Application 3/2020/0053: Demolition of timber garage. Extension of floor slab and erection of new garage at ground floor with workshop at first floor/roof level at Hougher Fall Old Clitheroe Road Dutton

PROJECT Hougher Fall Garage Replacement	DRAWING NO. A122	
SHEET Proposed Elevations	Scale (@ A3) 1 : 50	
CLIENT Julie Paton	Date JAN 20	REV

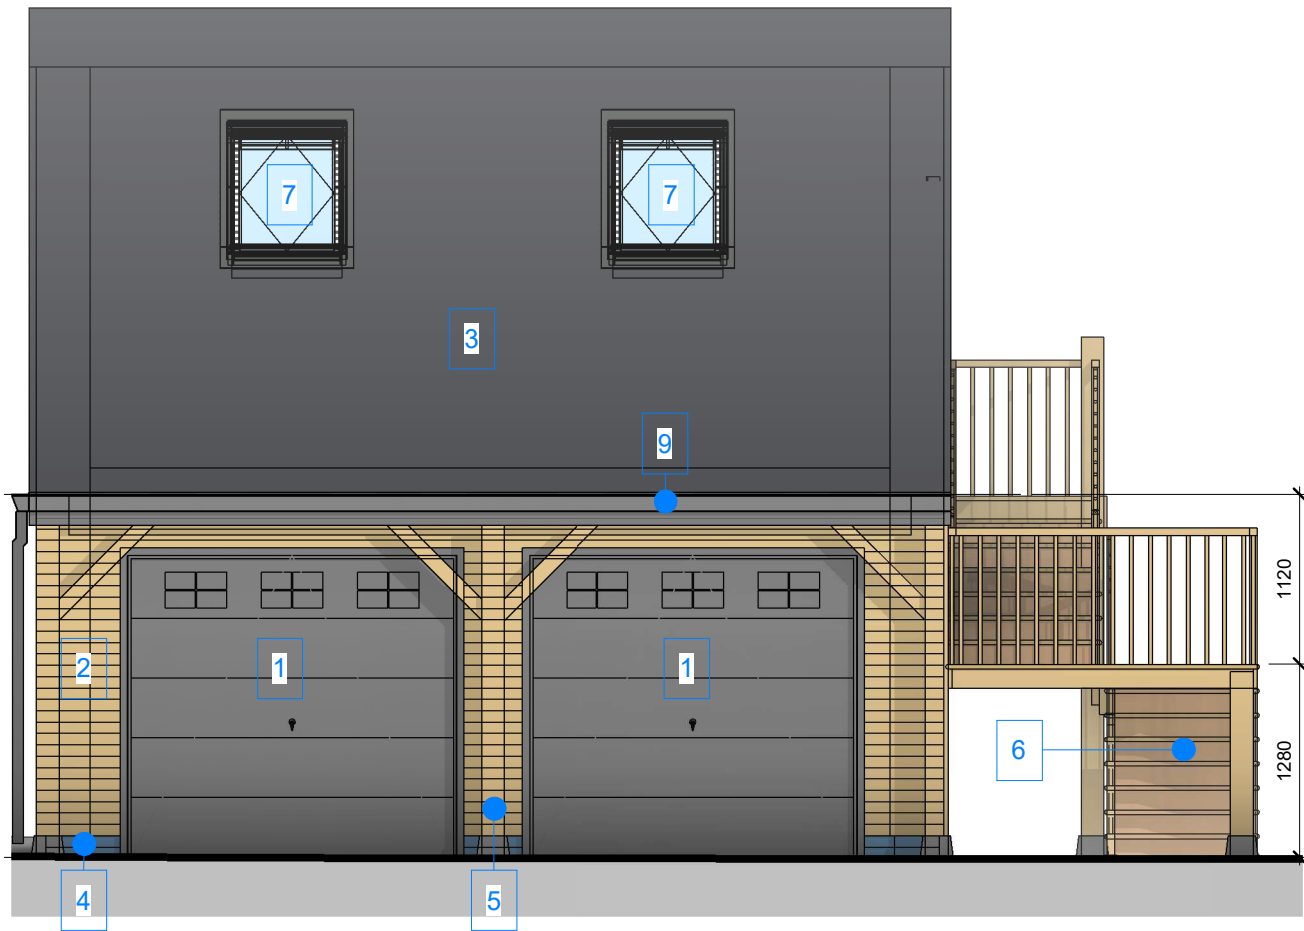
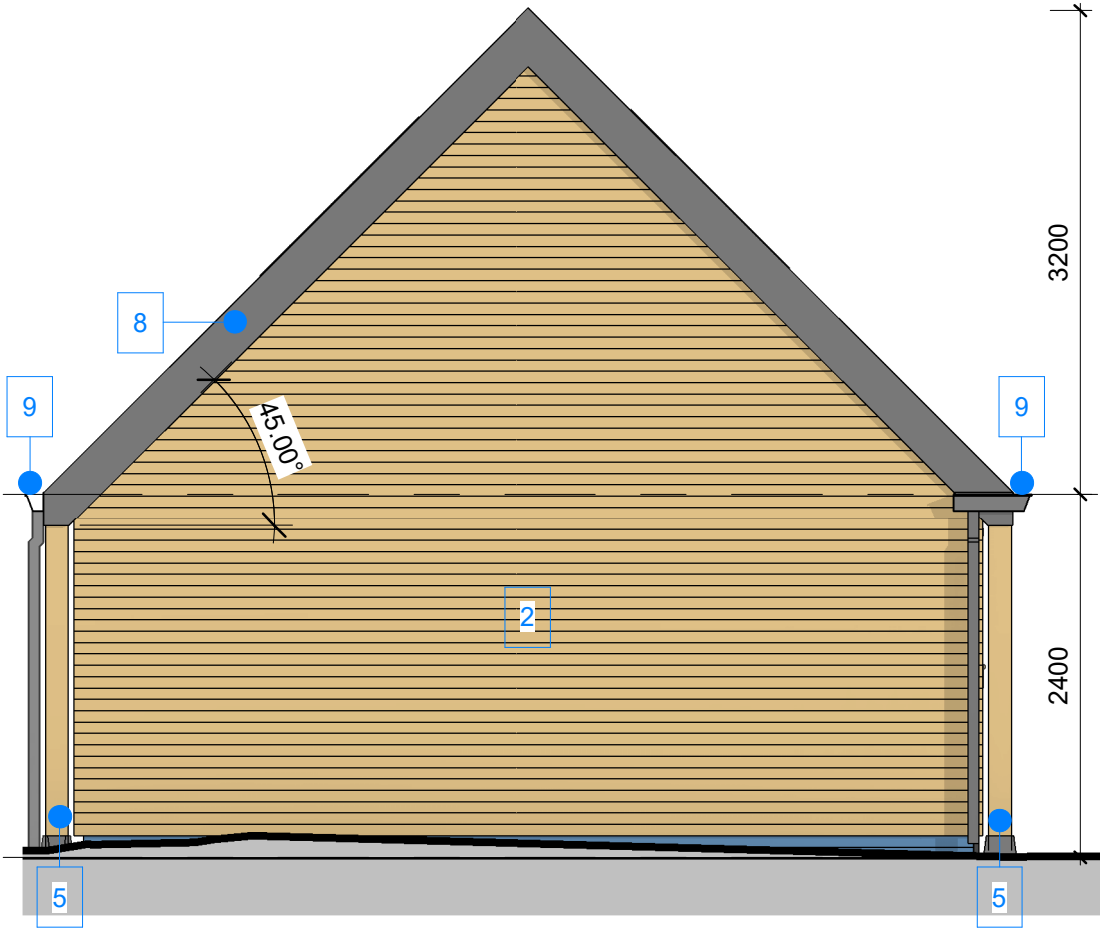
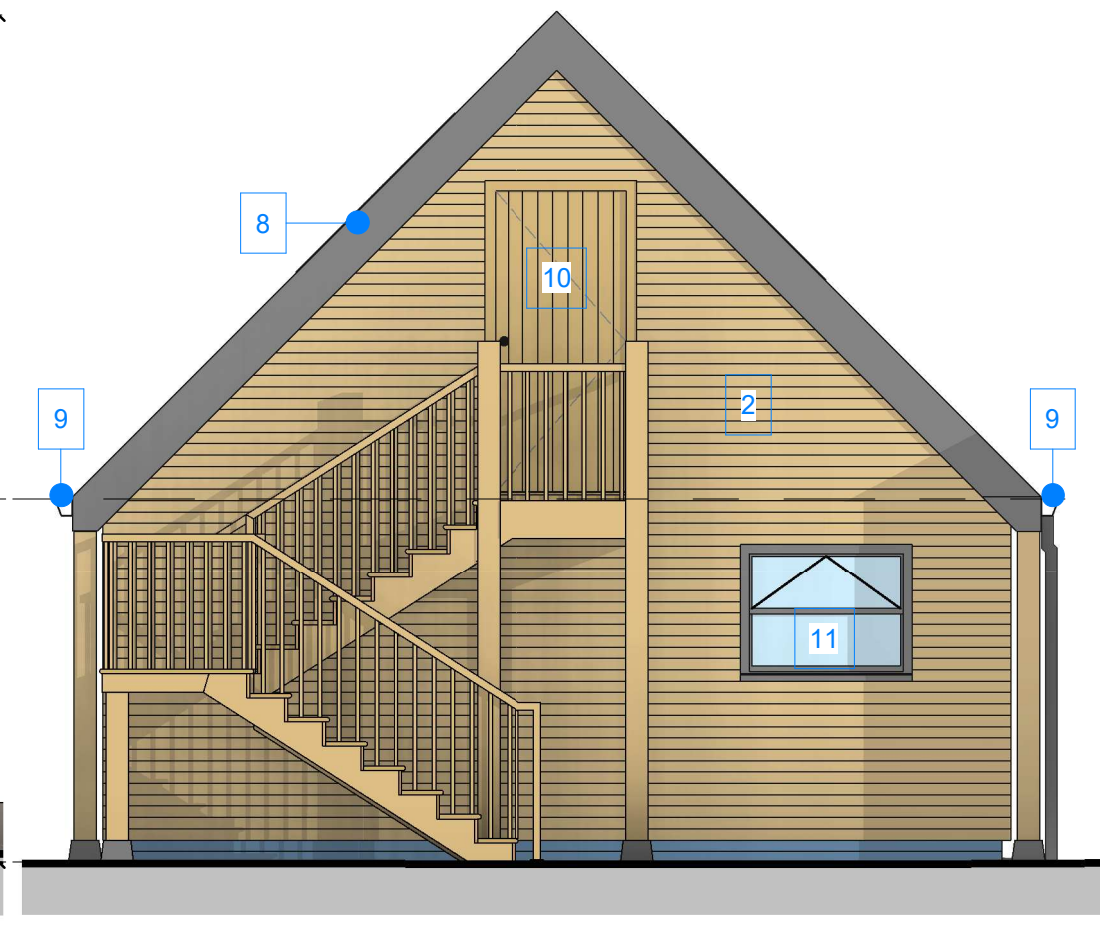
The inclusion of limited static viewpoints in the Heritage Statement and proposals for a larger and more prominent garage/workshop do not appear to have considered issues of cumulative impact and the potential variety of important views discussed in the NPPG and ‘The Setting of Heritage Assets’ (Historic England, 2017):

“It would not normally be good practice for new work to dominate the original asset or its setting in either scale, material or as a result of its siting” (paragraph 41)
<https://historicengland.org.uk/images-books/publications/making-changes-heritage-assets-advice-note-2/heag023-making-changes-to-heritage-assets/>
